Date: October 15, 2024

FROM: Margaret Haynes, NMDOT Assistant District 3 Traffic Engineer

SUBJECT: Aspire Traffic Study Update
Southeast quadrant of 118th Street and Amole Mesa Ave, North of NM 500
Albuquerque, Bernalillo County, New Mexico

The NMDOT received the DRAFT TIS dated July 2024. District Three's comments are below.

Figure 10: Coors Blvd and Rio Bravo Blvd (NM 500) HFIN Map

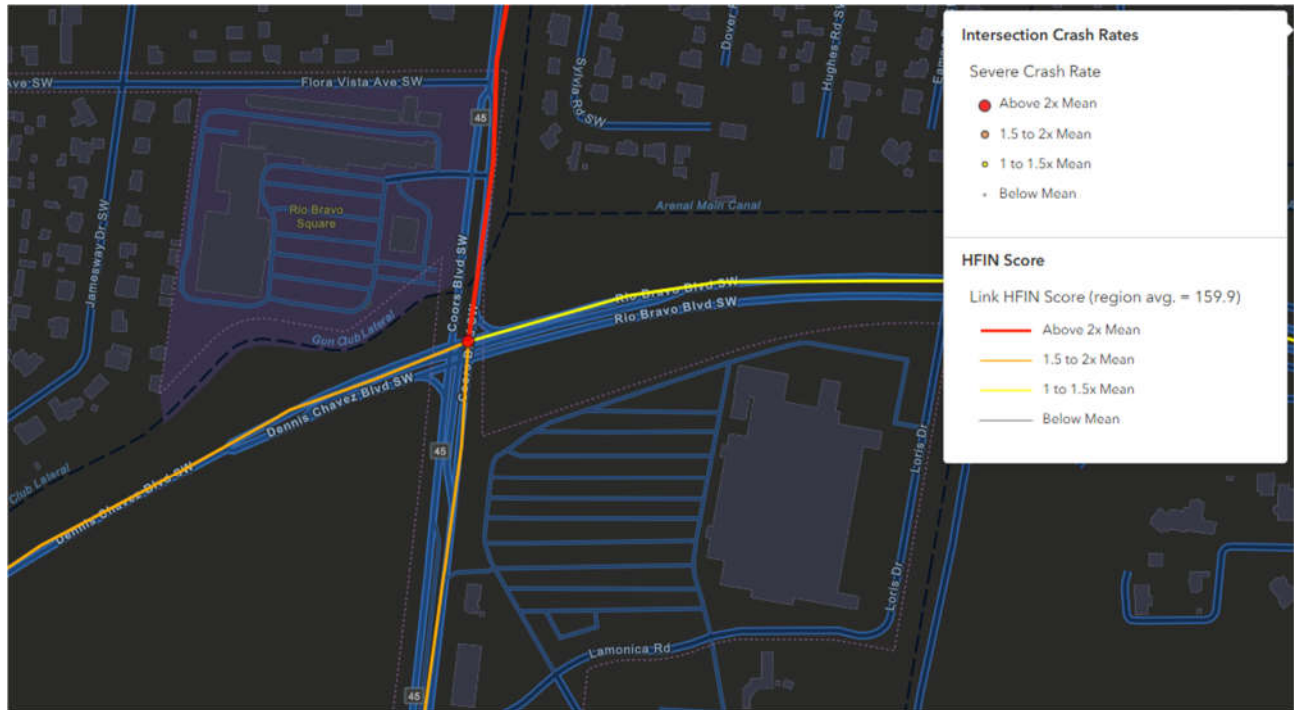
Page 8 – Please include MRCOG's HFIN map as a part of your Crash Summary.
